MEMORANDUM

RE: Vanderwall Residence Remodel, City of Mercer Island Permit Number: 2101-202

This memo summarizes my responses to the various structural items shown on the City of Mercer Island Corrections Notice dated May 6, 2021.

Drawing Title
ROOF FRAMING PLAN

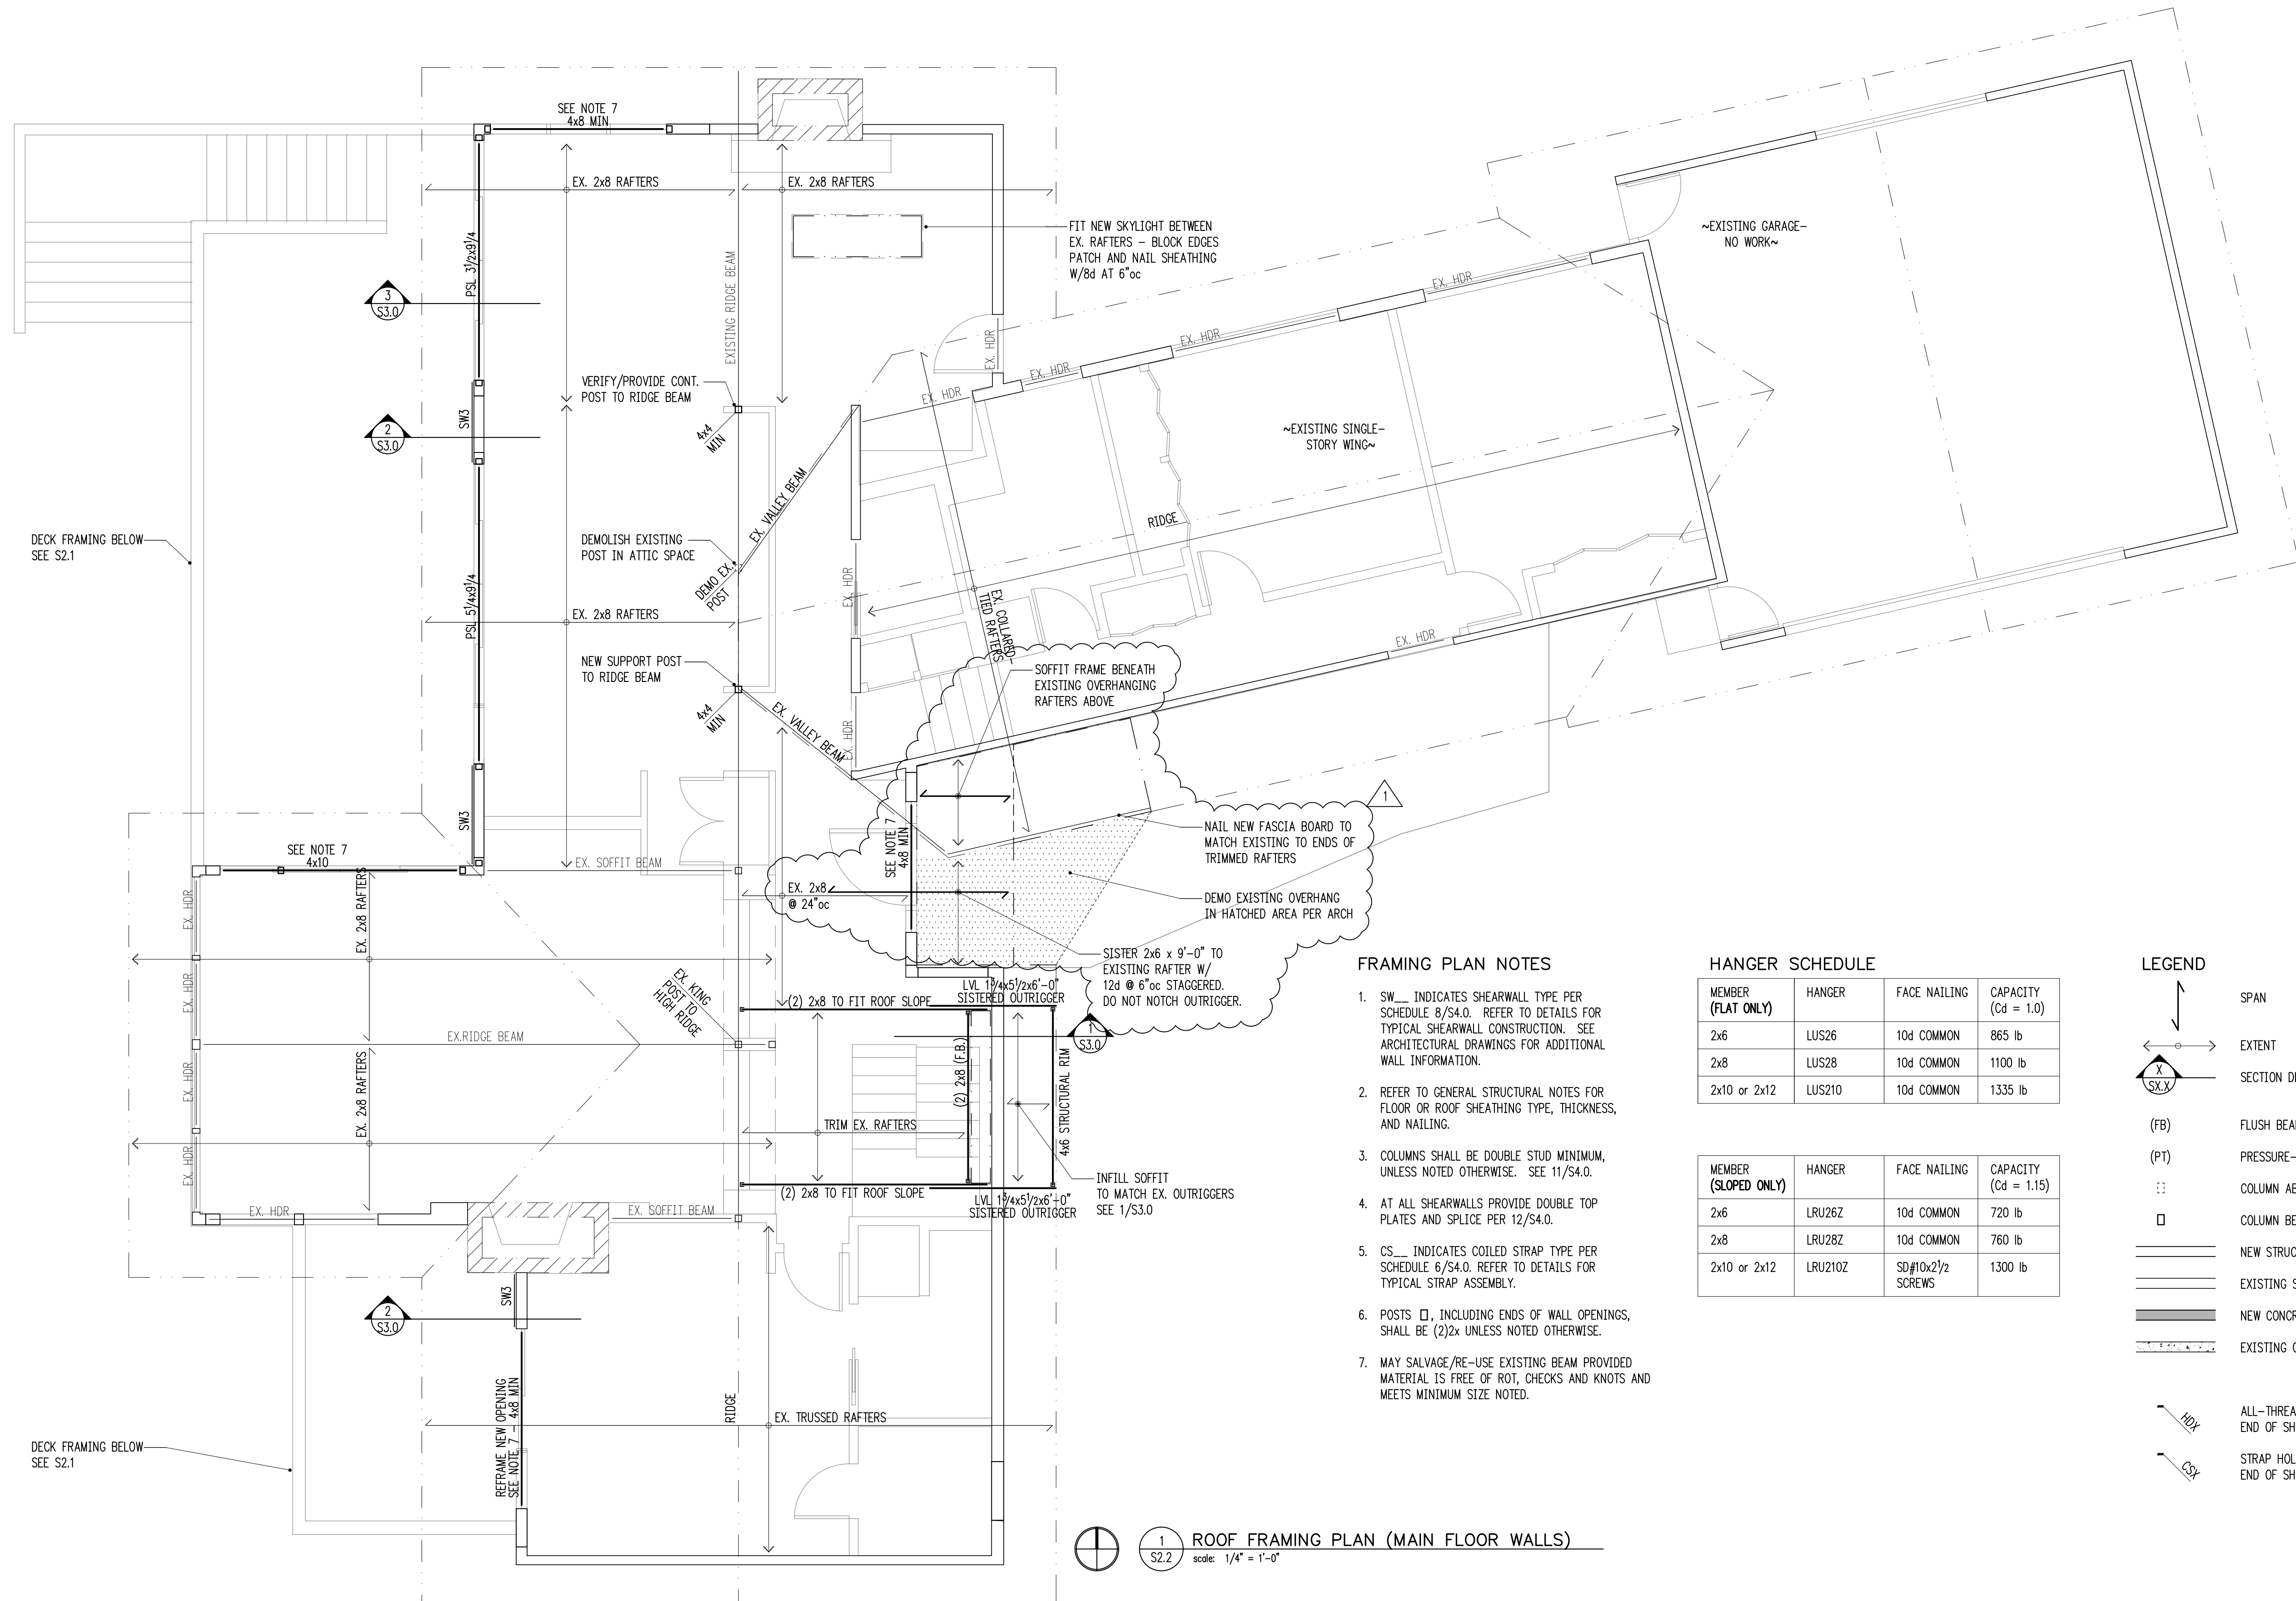
- S2.2** 1) *Please clarify construction this area. What are the existing rafters? Are they notched? What is the minimum backspan?*

- S2.2** 2) *This doesn't appear to be structurally sound. Please provide calculations and detailing demonstrating capacity of roof framing to resolve forces, including uplift.*

Notes have been changed to clarify framing intent.

Notes have been changed to clarify framing intent.

Drawing Number
S2.3

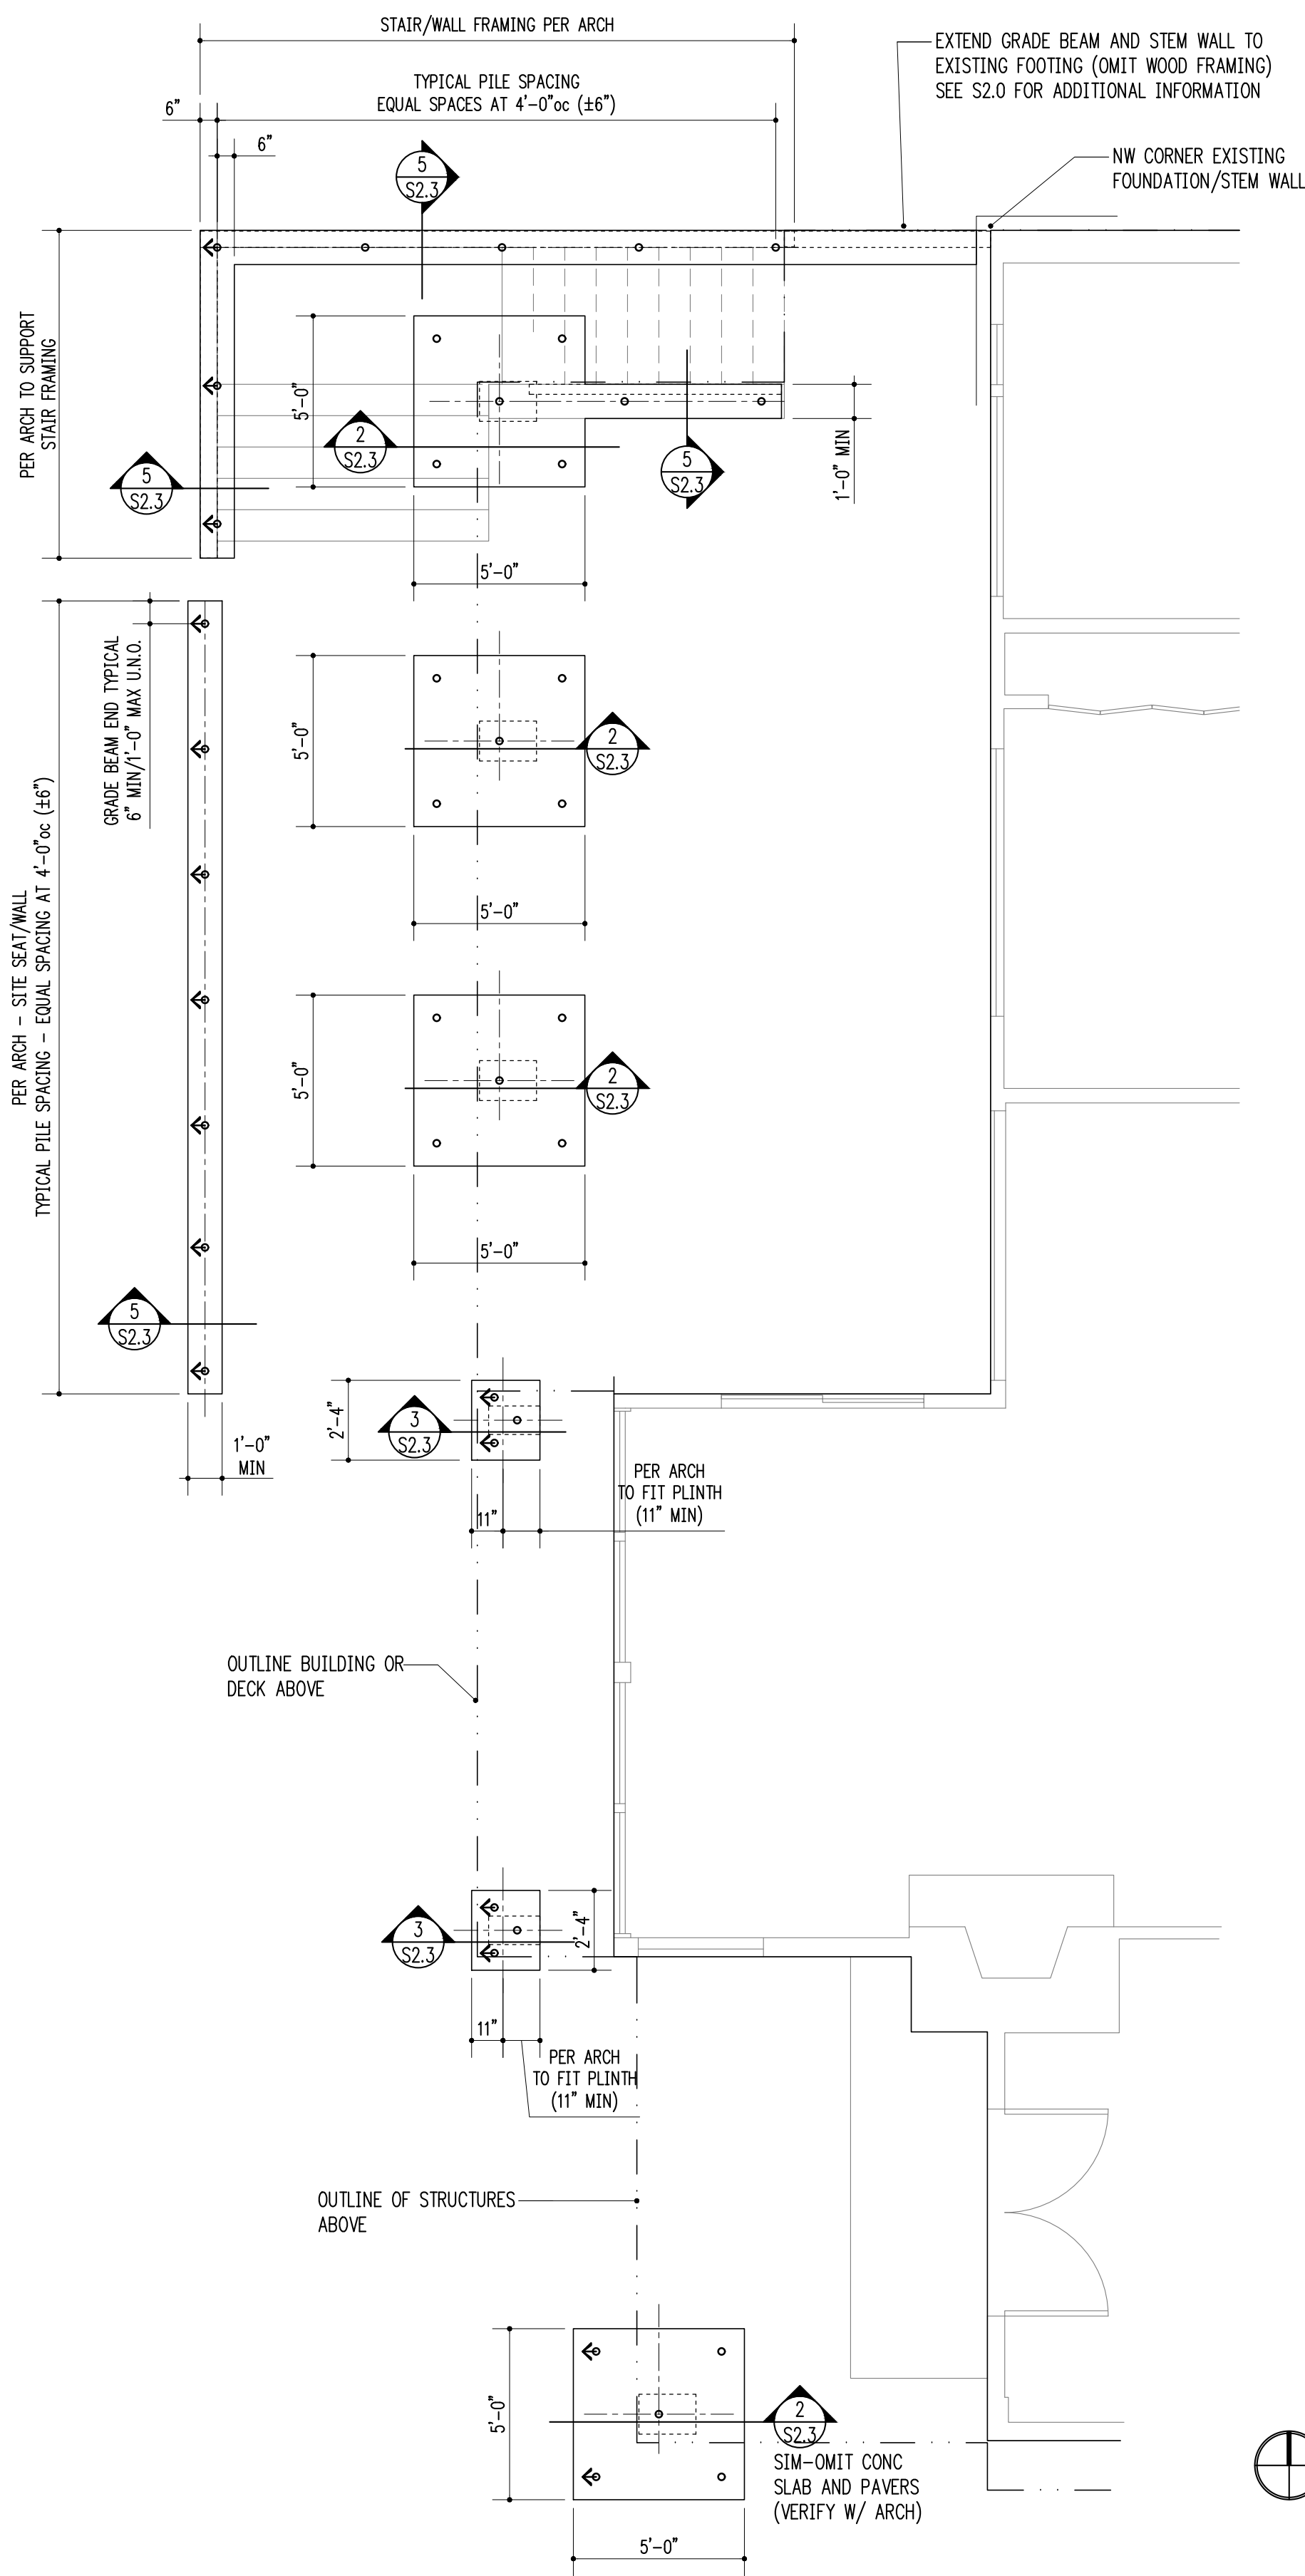
- S2.3** 1) *Please review anchor design. Shouldn't applied moment be M_y , not M_z ?*

S2.3 2) *Please indicate how eccentricity is resolved.*

See **Attachment C** calculations showing applied moment in correct direction.

Wall above is partial height with negligible loading, eccentricity is not expected to be an issue.
